Re: Uisce Éireann Compulsory Purchase (Adare Rationalisation) Order, 2025
Castleroberts, Adare, Co. Limerick.

**COMPULSORY ACQUISITION OF LAND
UISCE EIREANN COMPULSORY PURCHASE
(ADARE RATIONALISATION) ORDER 2025**

**Edward Houlihan,
Kilmacow, Kilfinny,
Adare,
Co. Limerick
(Objector)**

**Prepared by
FBA CONSULTANTS
FERMOY,
CO. CORK
10TH December 2025**

LAND ACQUISITION & WAYLEAVE

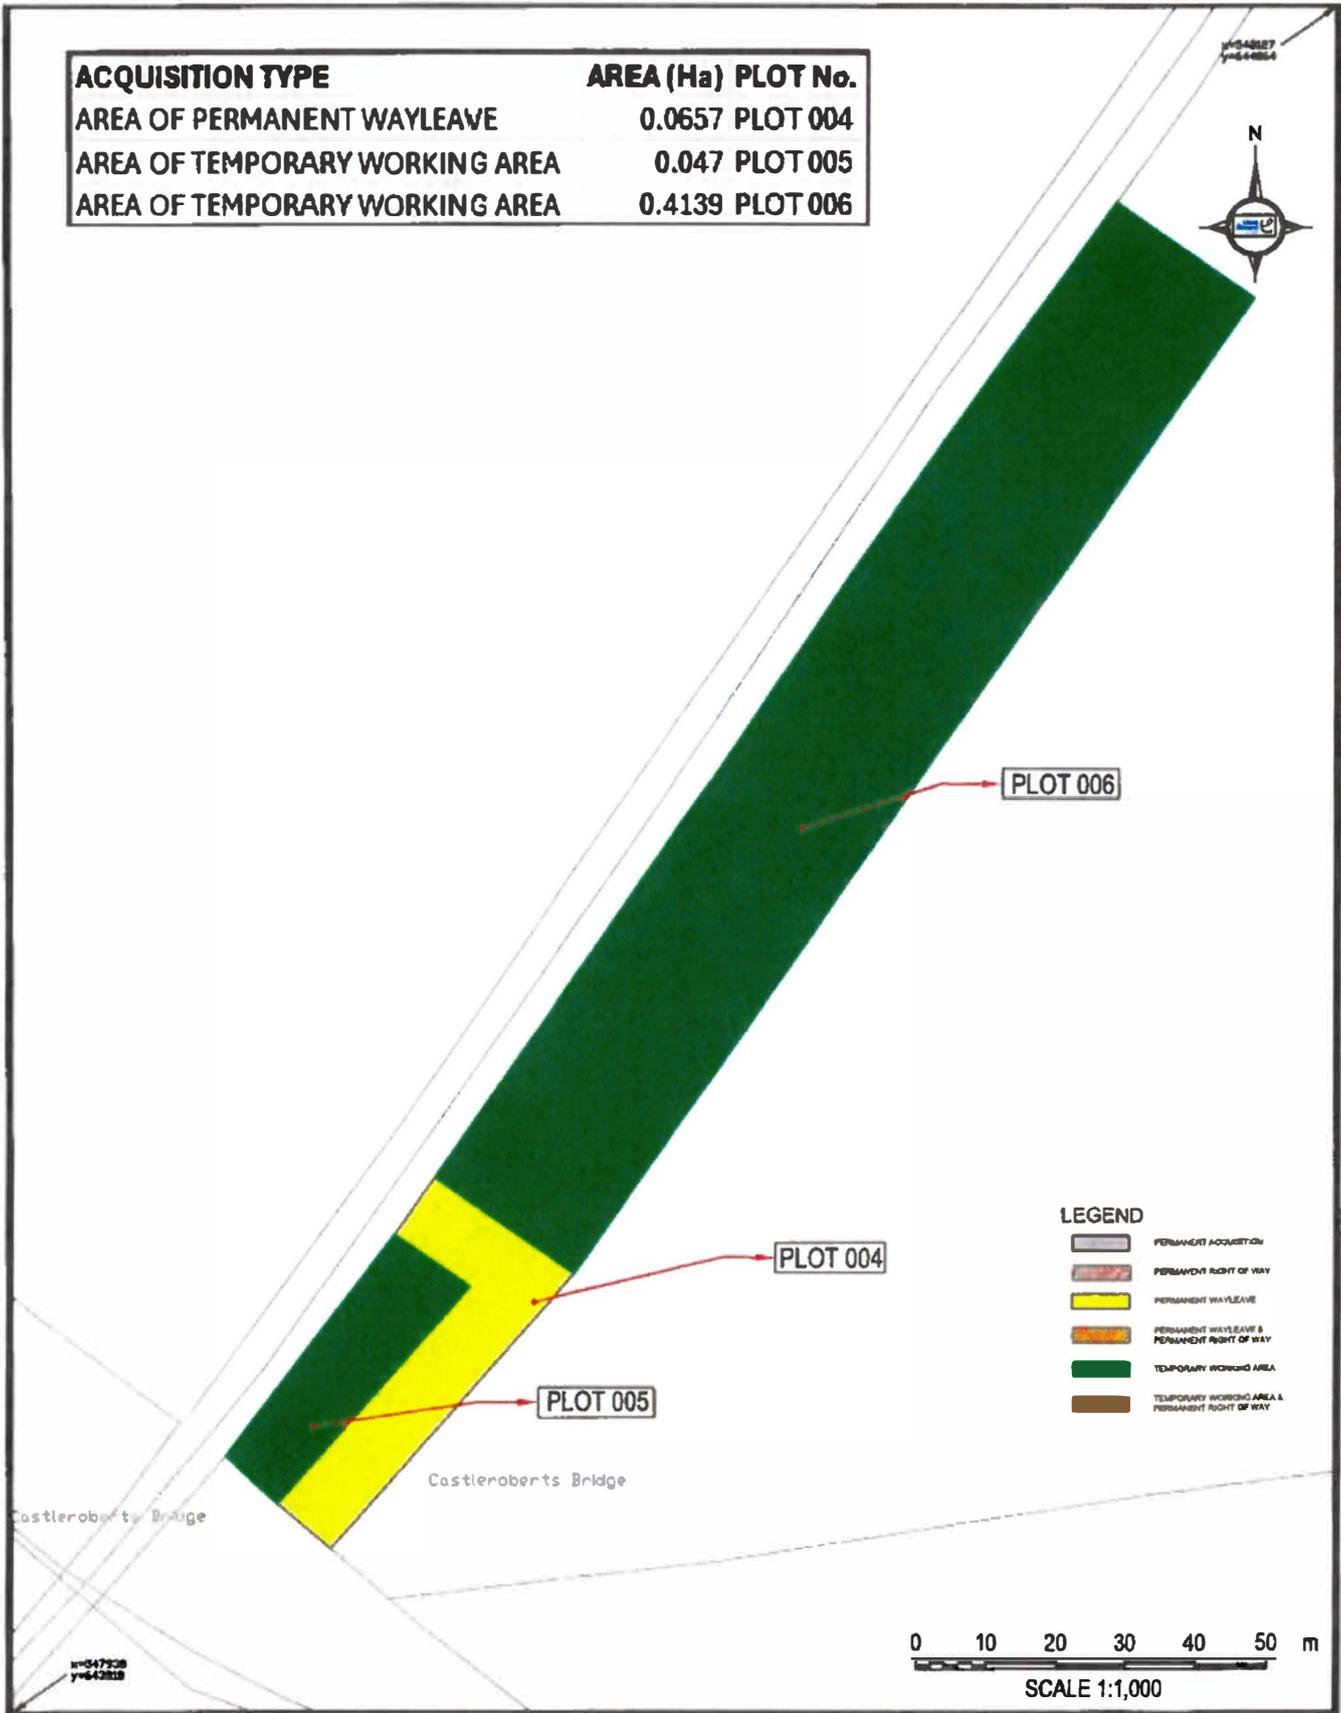
The Objector is opposed to the proposed route of the scheme and requests that it be relocated to the opposite side of the public road from his holding. This alignment would place the entire scheme on the same side as the existing treatment plant. The proposed route requires two road crossings and has at least three right angle joints which compromise pressure and are more prone to leaks. The proposed route has a greater cumulative impact on the three affected adjacent holdings at this location. The requested route therefore represents the more logical and appropriate route.

The Objector has been advised that he will lose a residential site for his son at the most favourable location on his holding. (see appendix 2)

The proposed trenchless crossing of the river is not without risk. There will be pits on either bank and a lot of noise and vibration and potential fissures that may cause the river water to leak into the bore chamber and allow the release of chemicals from the process up to contaminate the river. **This is a major risk to the Adare water supply as the proposed route is upstream of the water treatment plant's intake suction pipe. The Objector's requested route is downstream and therefore any potential contamination of the Adare water supply from a trenchless crossing would be averted.** The trenchless process has further potential adverse impacts for the river and its banks and for resident protected fauna like otters, horseshoe bats, salmonoids, lamprey, crayfish and mussels, and as already stated, the Objector's side of the bridge is more sensitive.
